Our ref: DA-384/2019
Your Ref: SSD-10352

WAVERLEY COUNCIL SUBMISSION
State Significant Development Application (SSD-10352) for Moriah College Redevelopment
Queens Park Road, Queens Park
(Waverley Council Ref.: DA-384/2019)

SECURITY STRATEGY

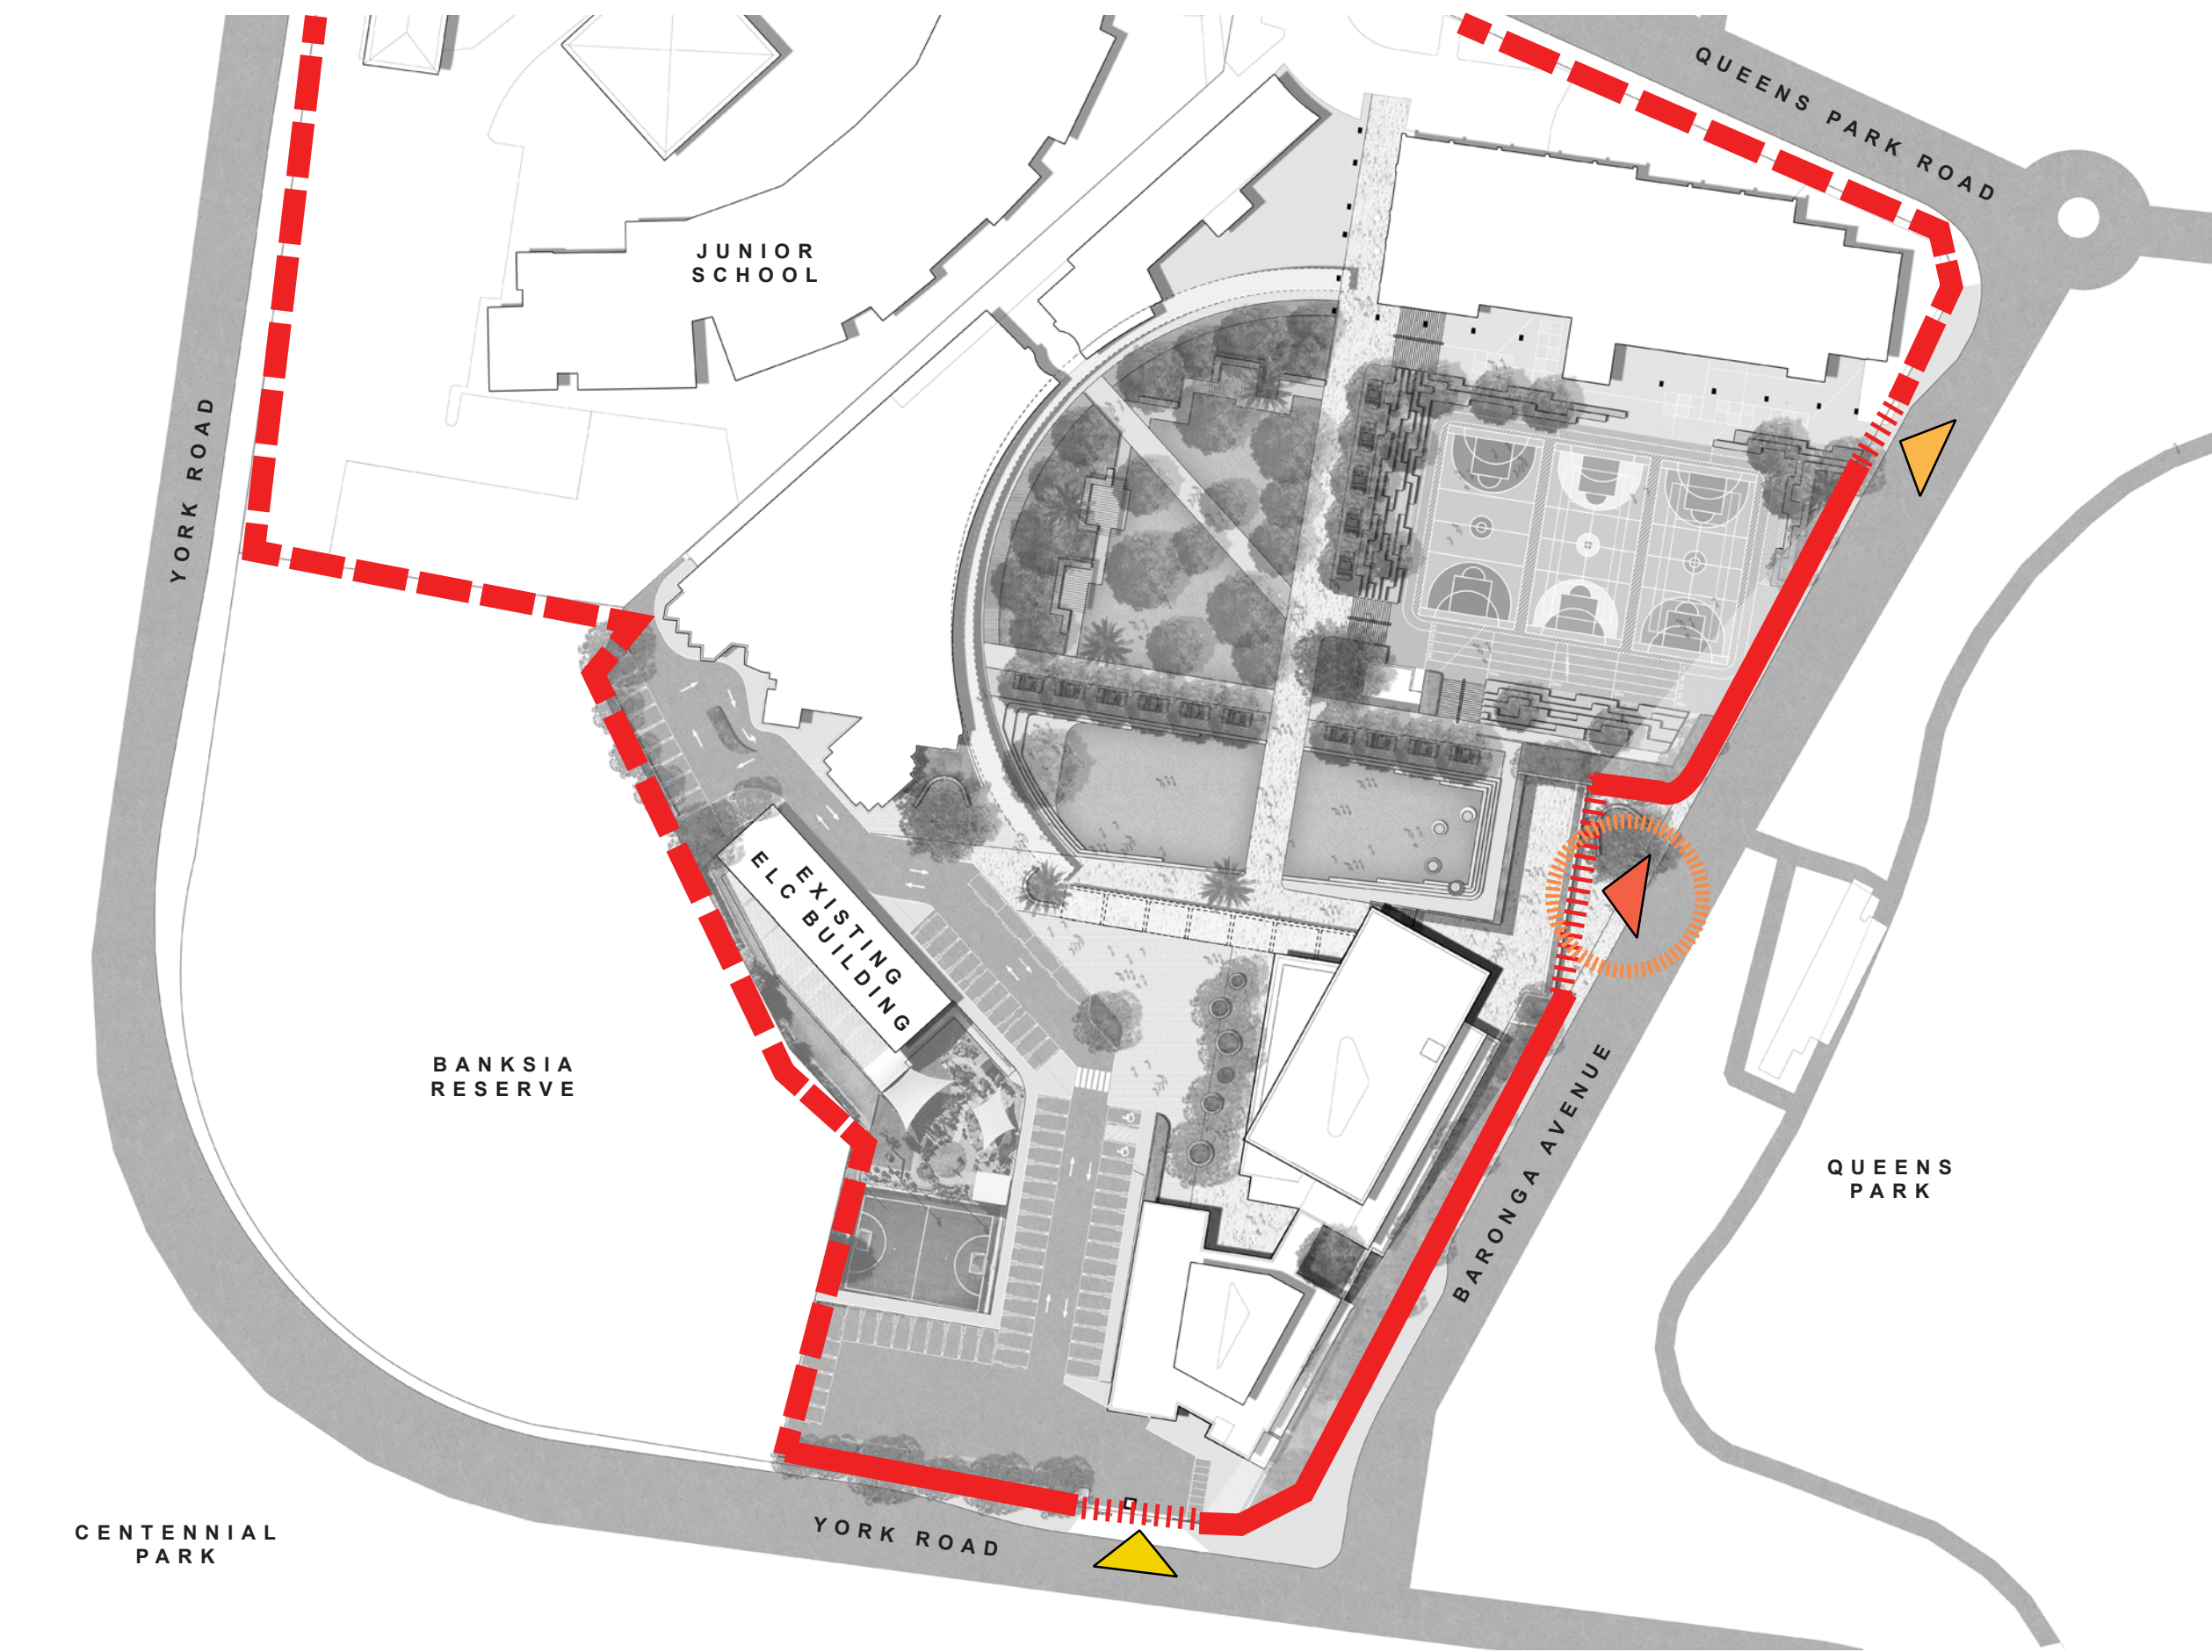
- v. The new security wall is lacking detail and resolution; the alignment is demonstrated in the landscape package with no specific detail of the material, treatment or construction type. The interpretive elements are supported, however greater clarity on the type of wall is required. It is recommended that the wall is integrated into the existing landscaped retaining wall with additional vegetation to screen the wall or integrated into building to reduce the visual impact of a large security wall.
